September 25, 2008

RE: Western Pacific Segregation, SEG-08-00030

Parcel #: 617934
Legal: Section 36 T19NR17E

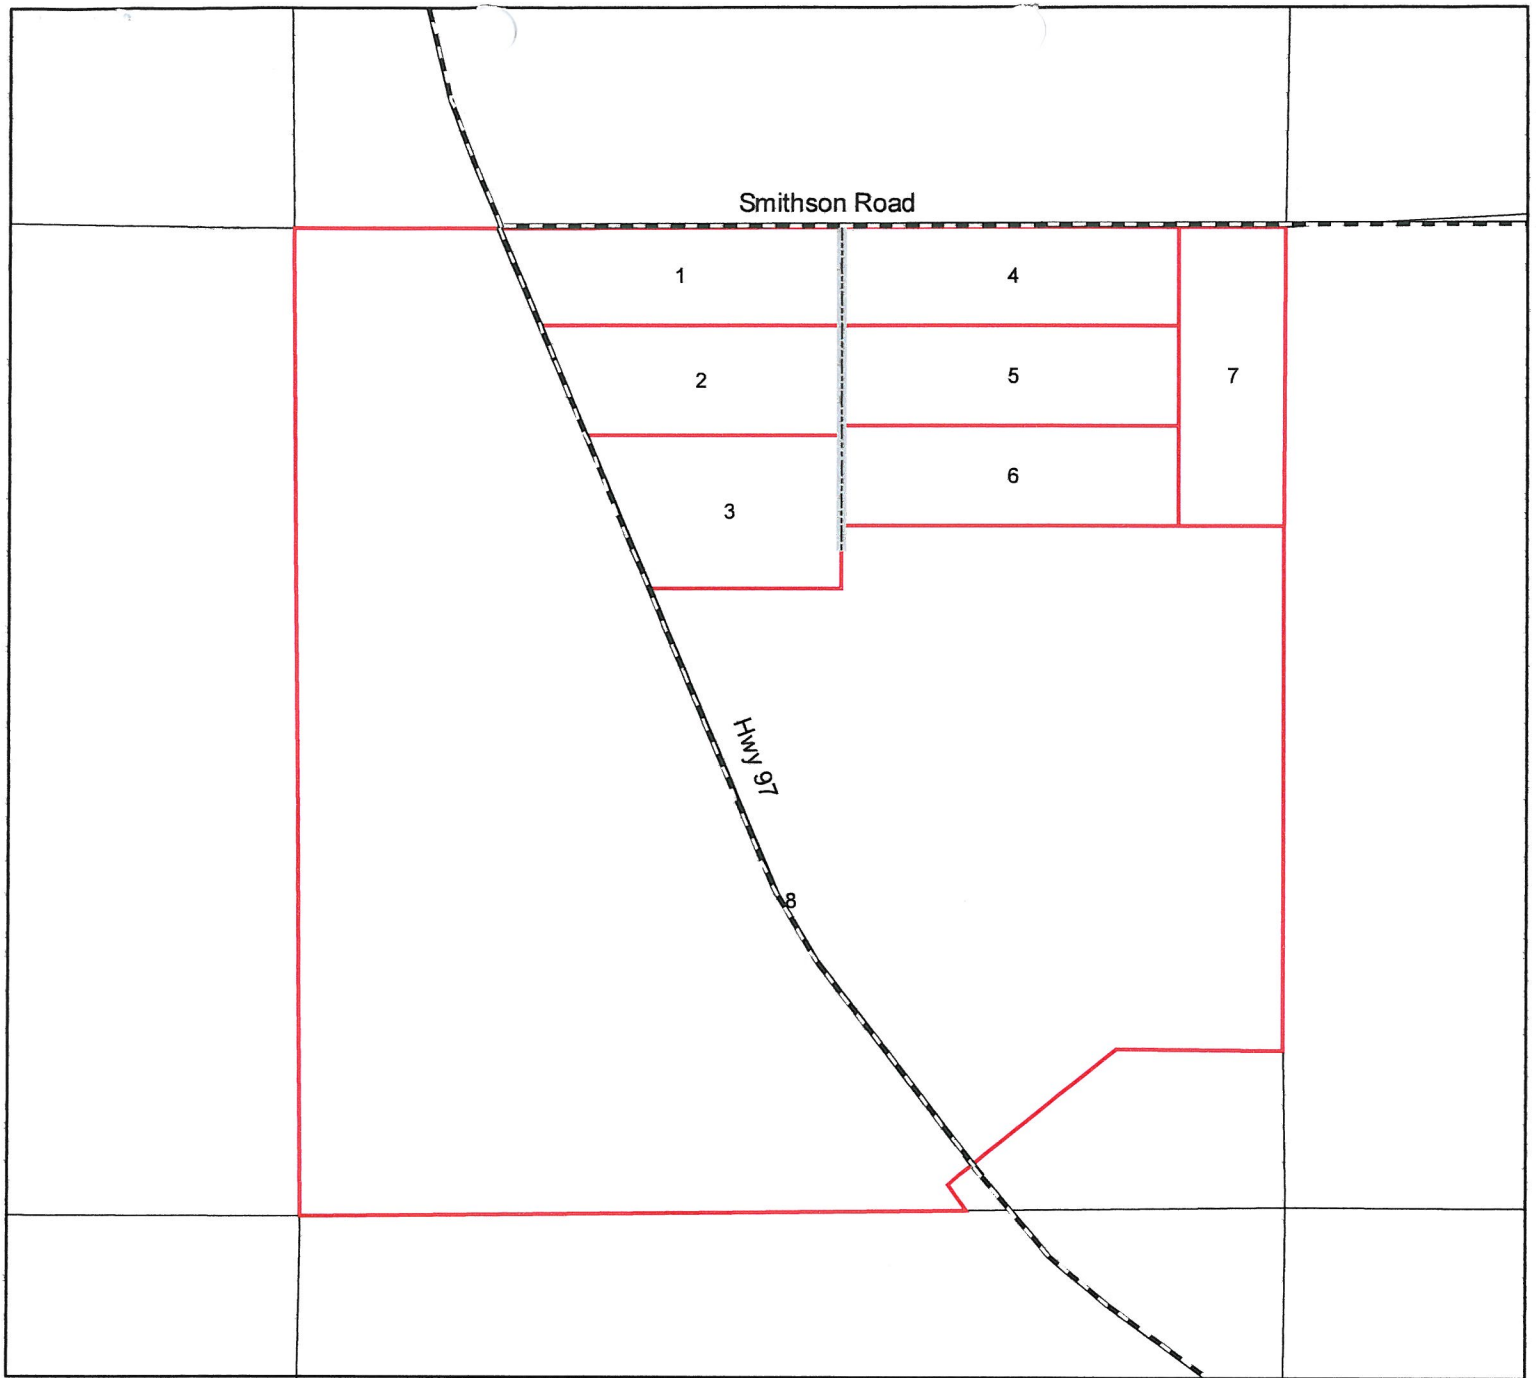
4. Please refer to the attached Kittitas County Public Works Memo for information regarding additional requirements.
5. Please refer to the attached Washington State Department of Transportation Memo for information regarding any additional requirements. A letter of approval shall be received from the WSDOT stating that the proposed parcel creation meets all requirements prior to final approval. It is the applicant's responsibility to contact WSDOT to fulfill any access requirements.
